Our Ref: EN010077

Date: 22 November 2019

Application by ScottishPower Renewables for an Order Granting Development Consent for the East Anglia ONE North Offshore Wind Farm

Advice following issue of decision to accept the application for examination

Legend

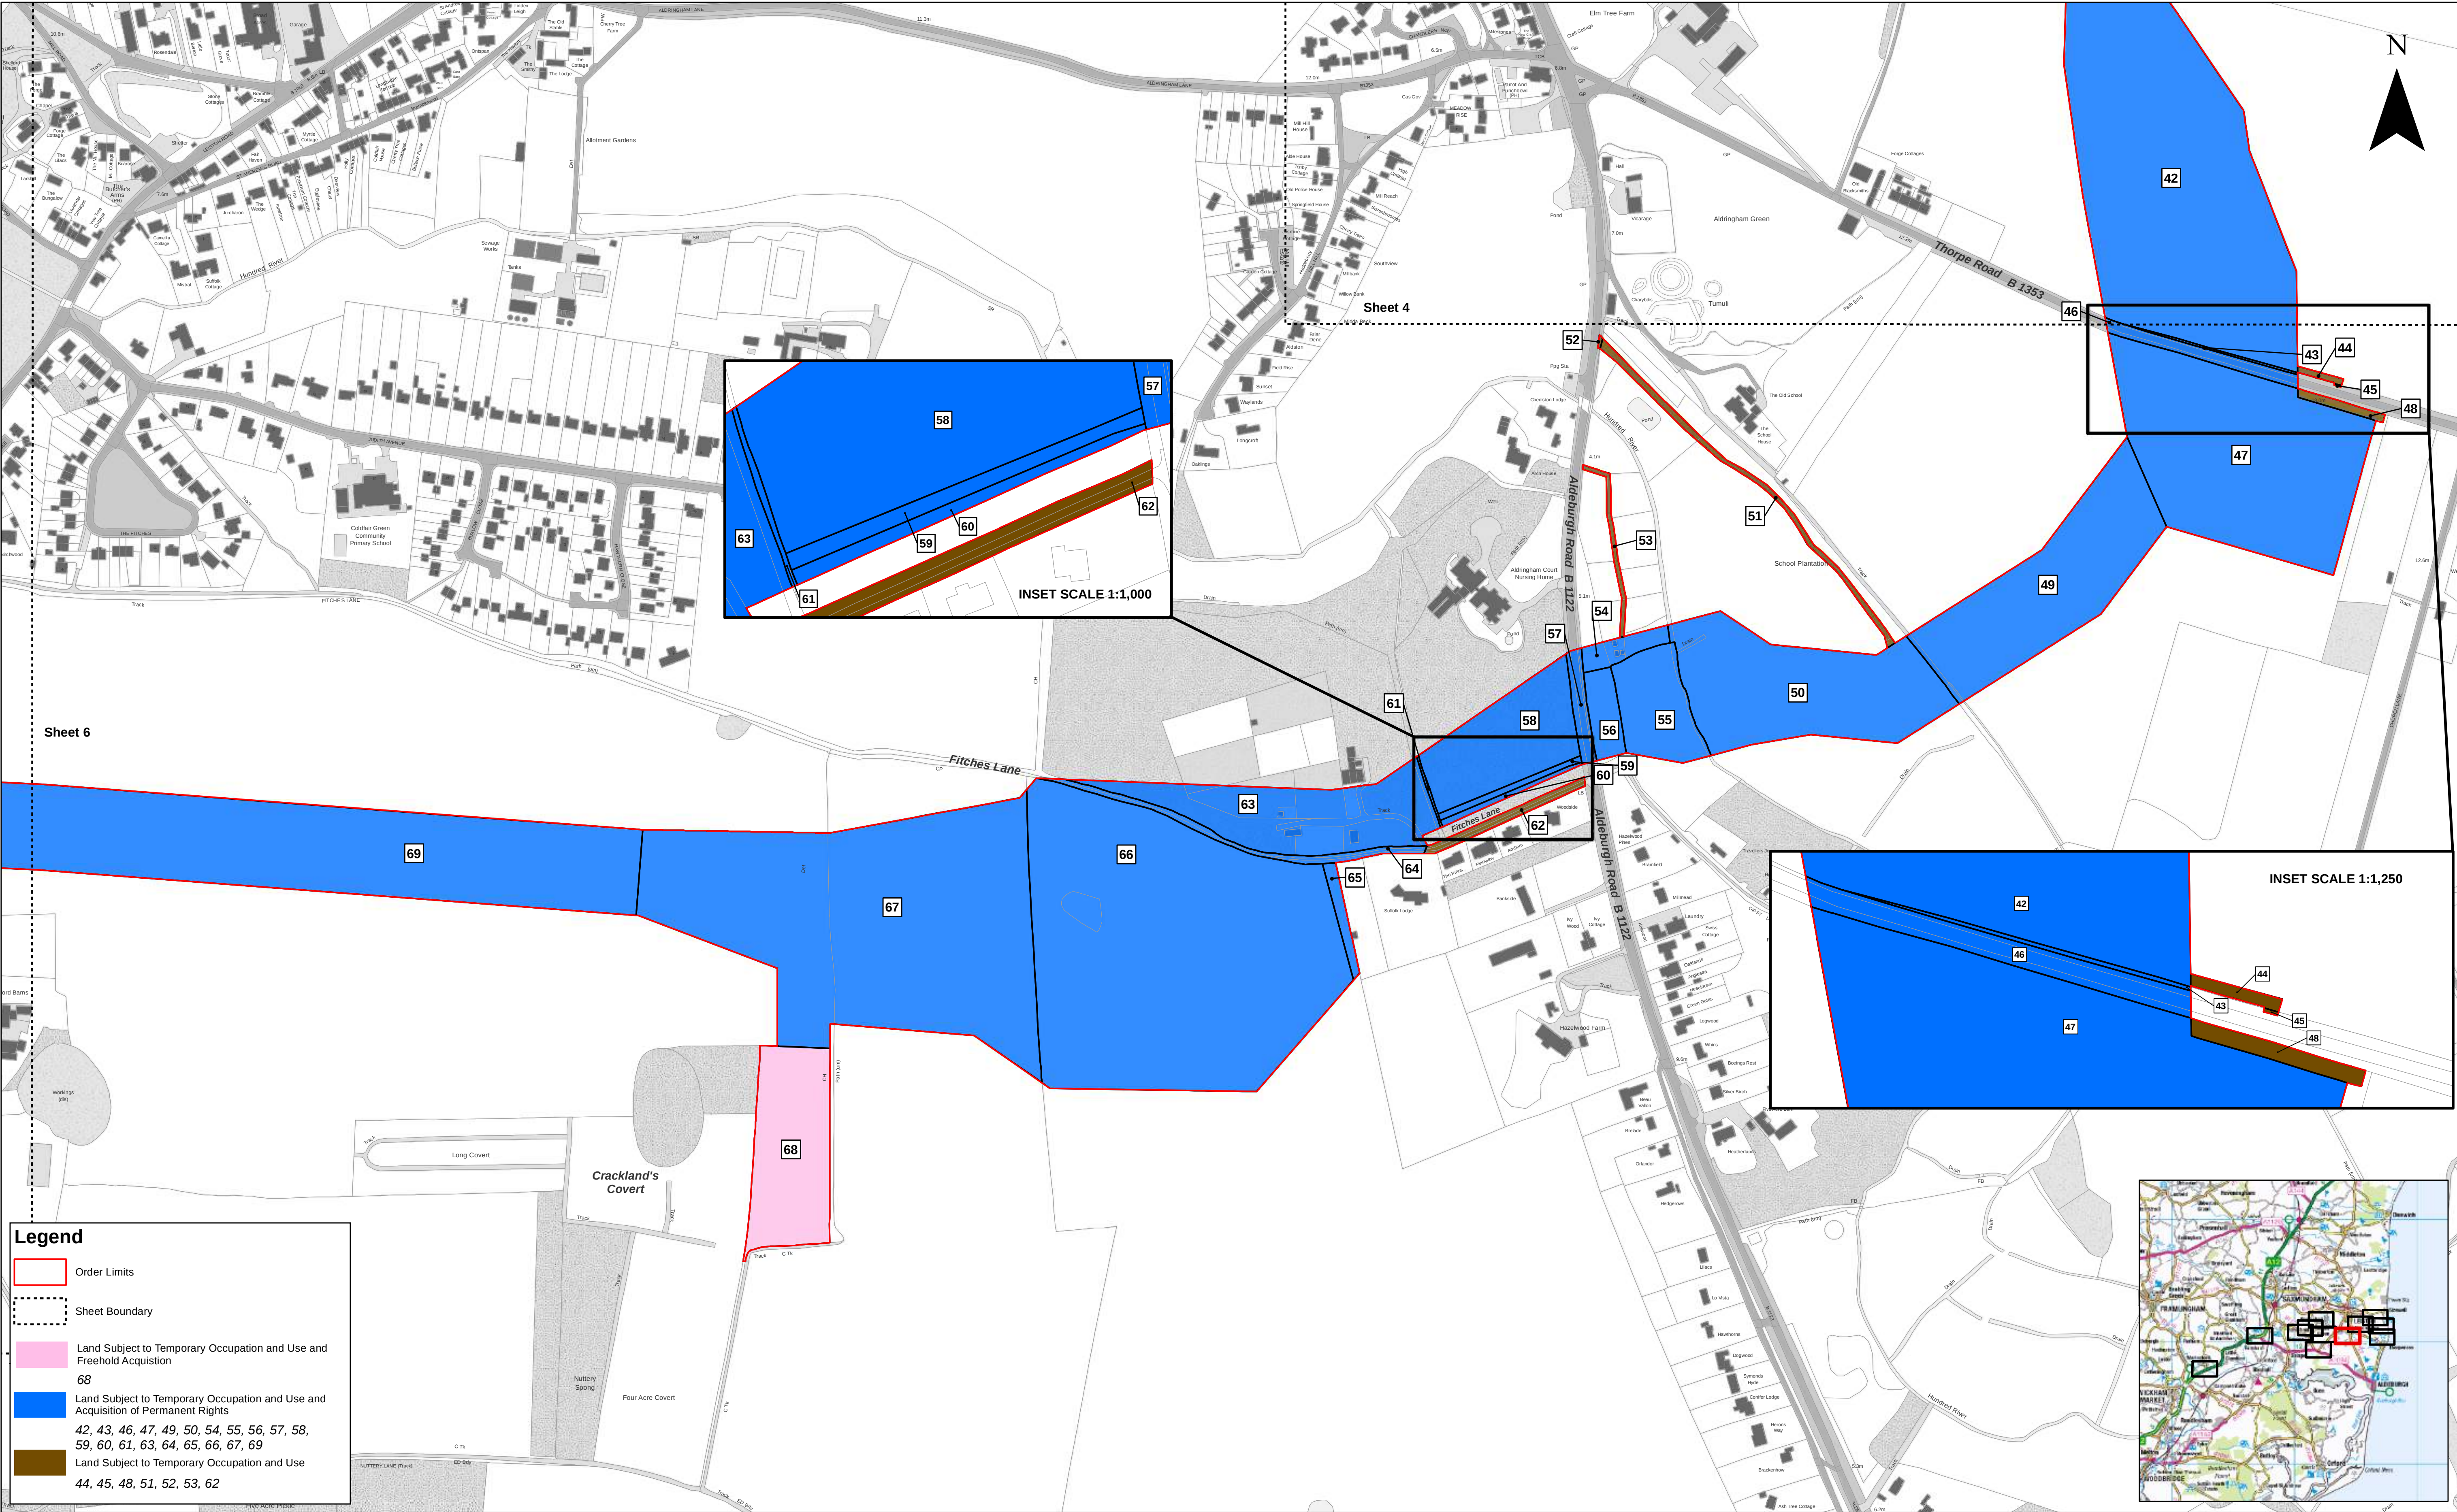
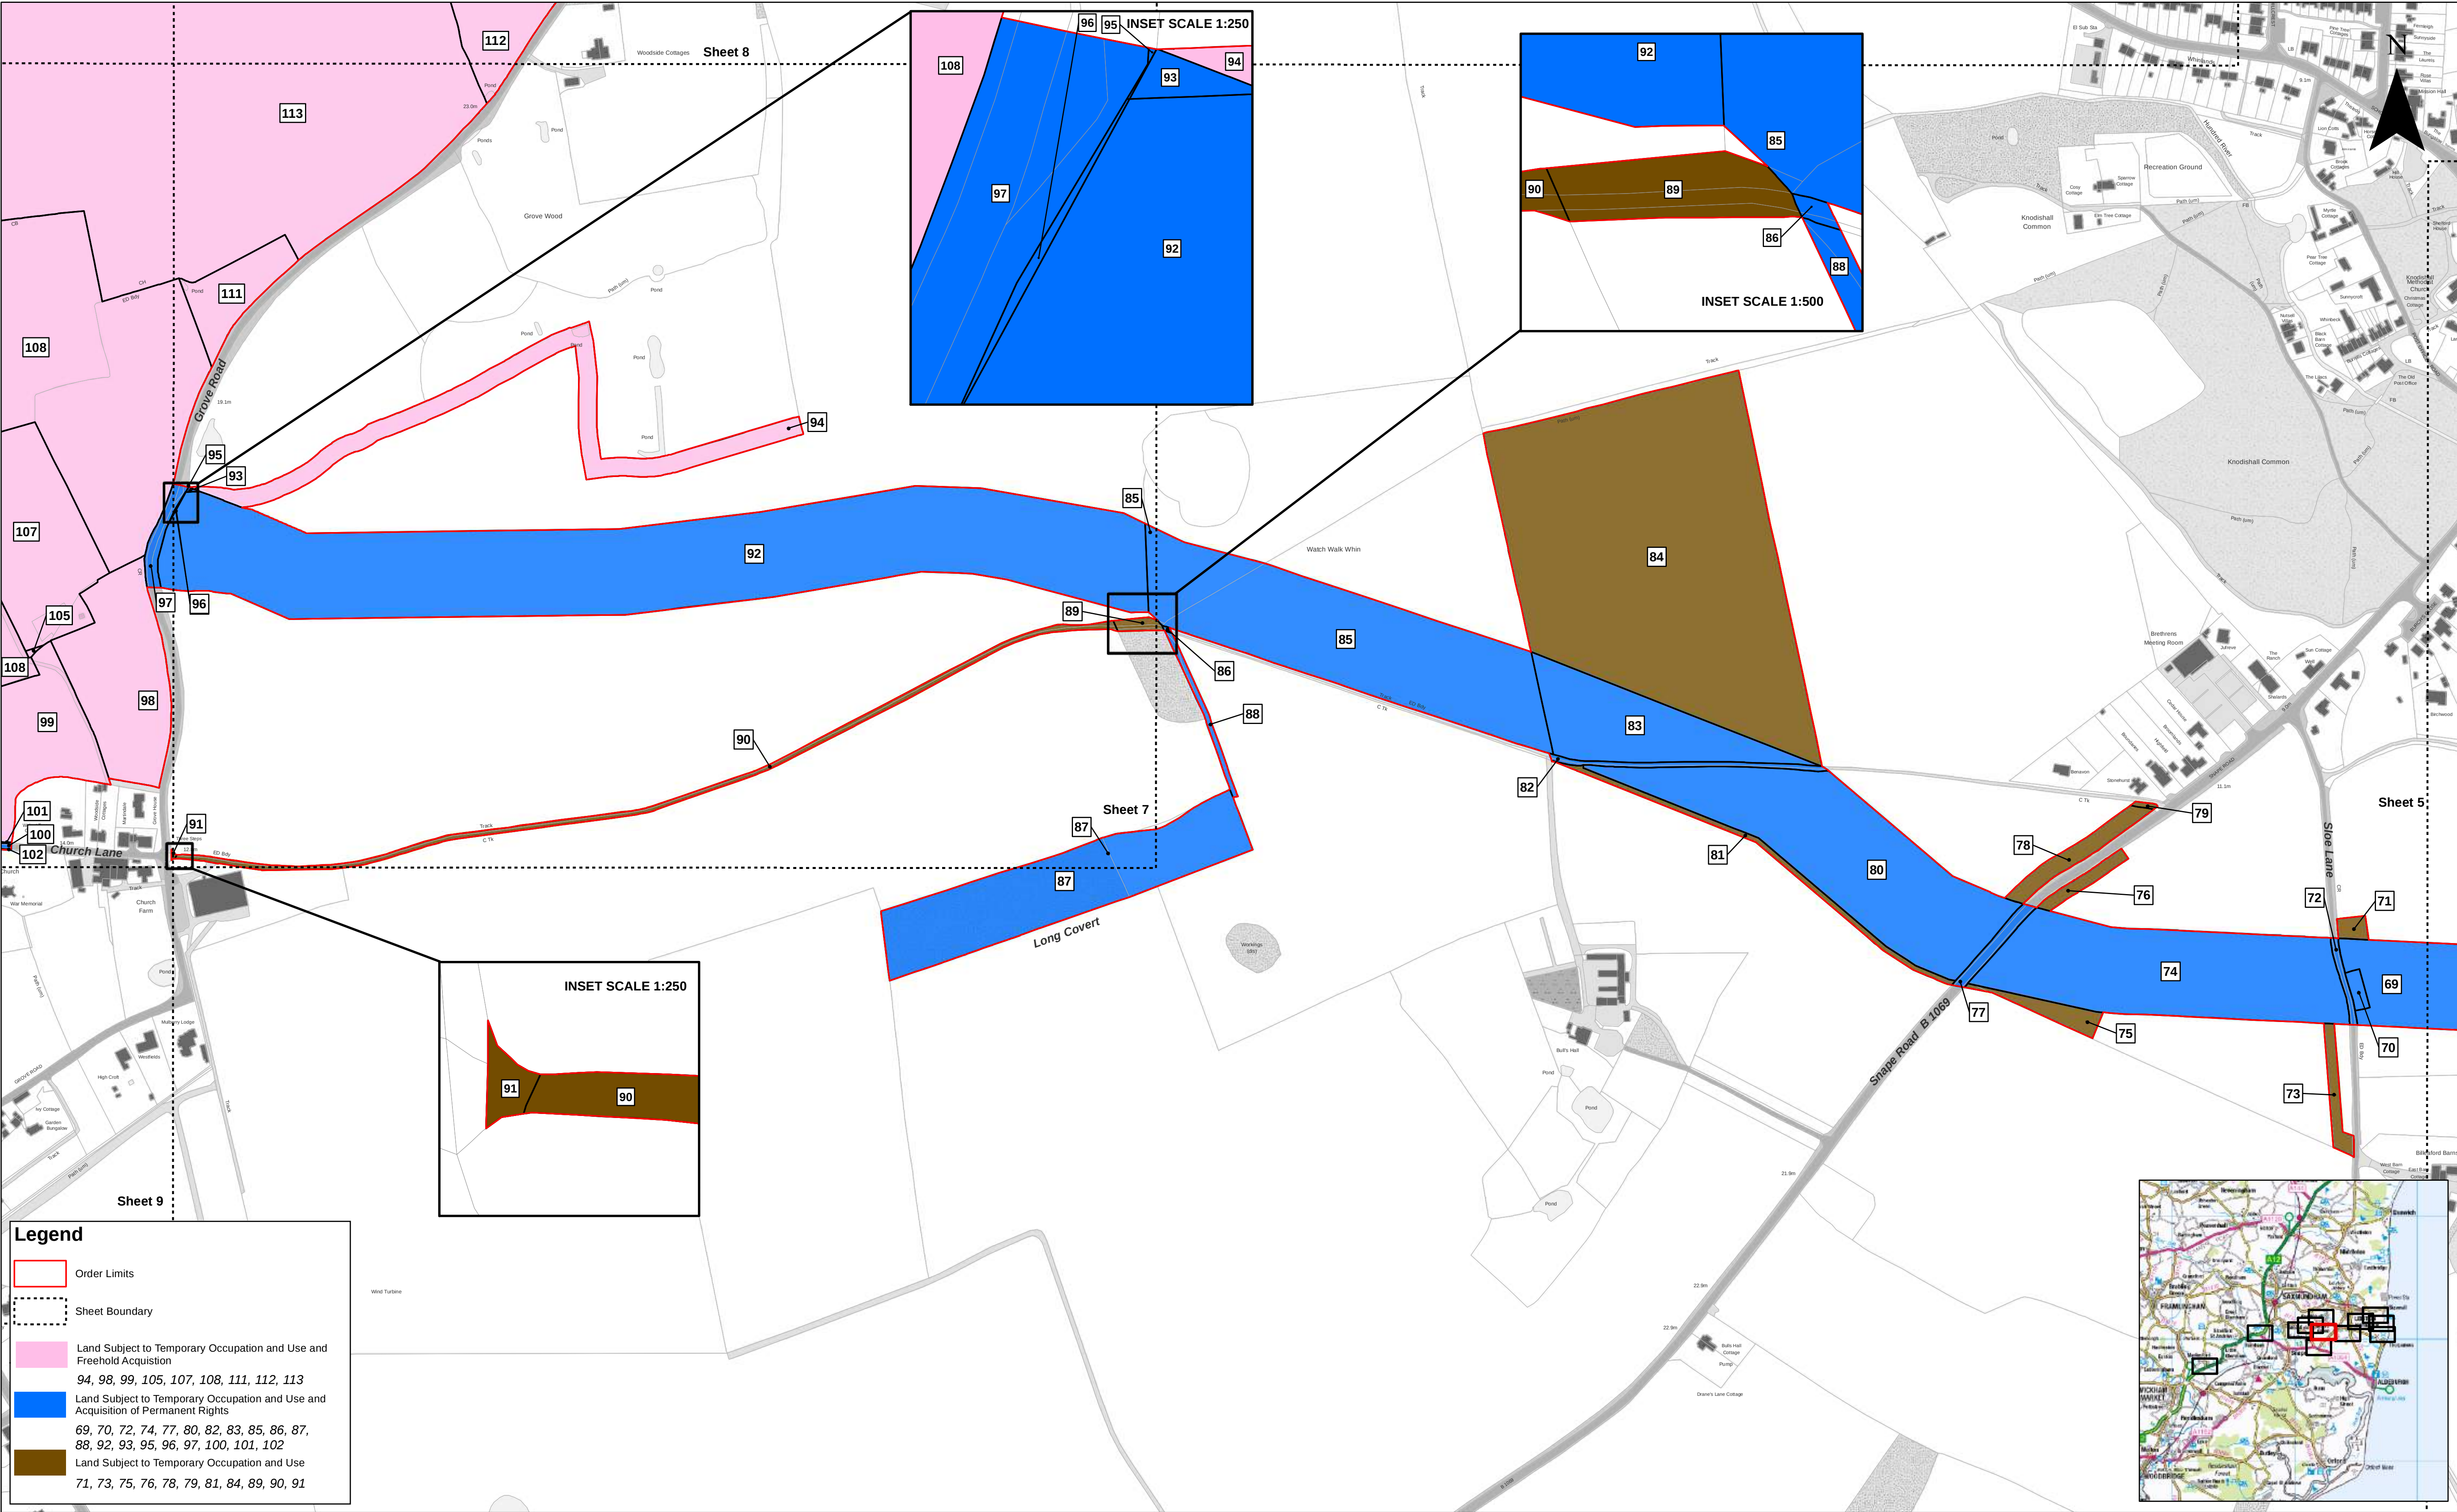
The Applicant is advised to carry out a full check of the BoR to ensure all information provided is complete and accurate. An introduction to the document may aid the reader. Although this is not formally required to comply with the legislation or Guidance, such an introduction has been included in some recent applications. Please provide updated Land Plans which include:

- The names of all relevant landmarks described in Column 2 ('Extent of acquisition or use') of the BoR (e.g. Sizewell Estate, Sizewell Gap, Grimsey's Lane, Blackheath Estate, Redhouse Farm and Knodishall Hall) should also be shown on the relevant Sheets of the Land Plans.

- Road names on the Land Plans to assist the identification of land should be shown more clearly.
- Larger and clearer landmarks on the relevant Sheets of the Land Plans.

- The same map base as the other submitted plans and sheet layout. (It was noted in the checklist that the Land Plans have used a different map base to the other submitted plans, and this makes comparison between the Land Plans and the other submitted plans more difficult than it needs to be.)

- Additional insets. (It was noted in the checklist that Plots 18, 91 and 126 would benefit from being shown on an inset plan.)
- Corrected Plot number for inset 9.4.
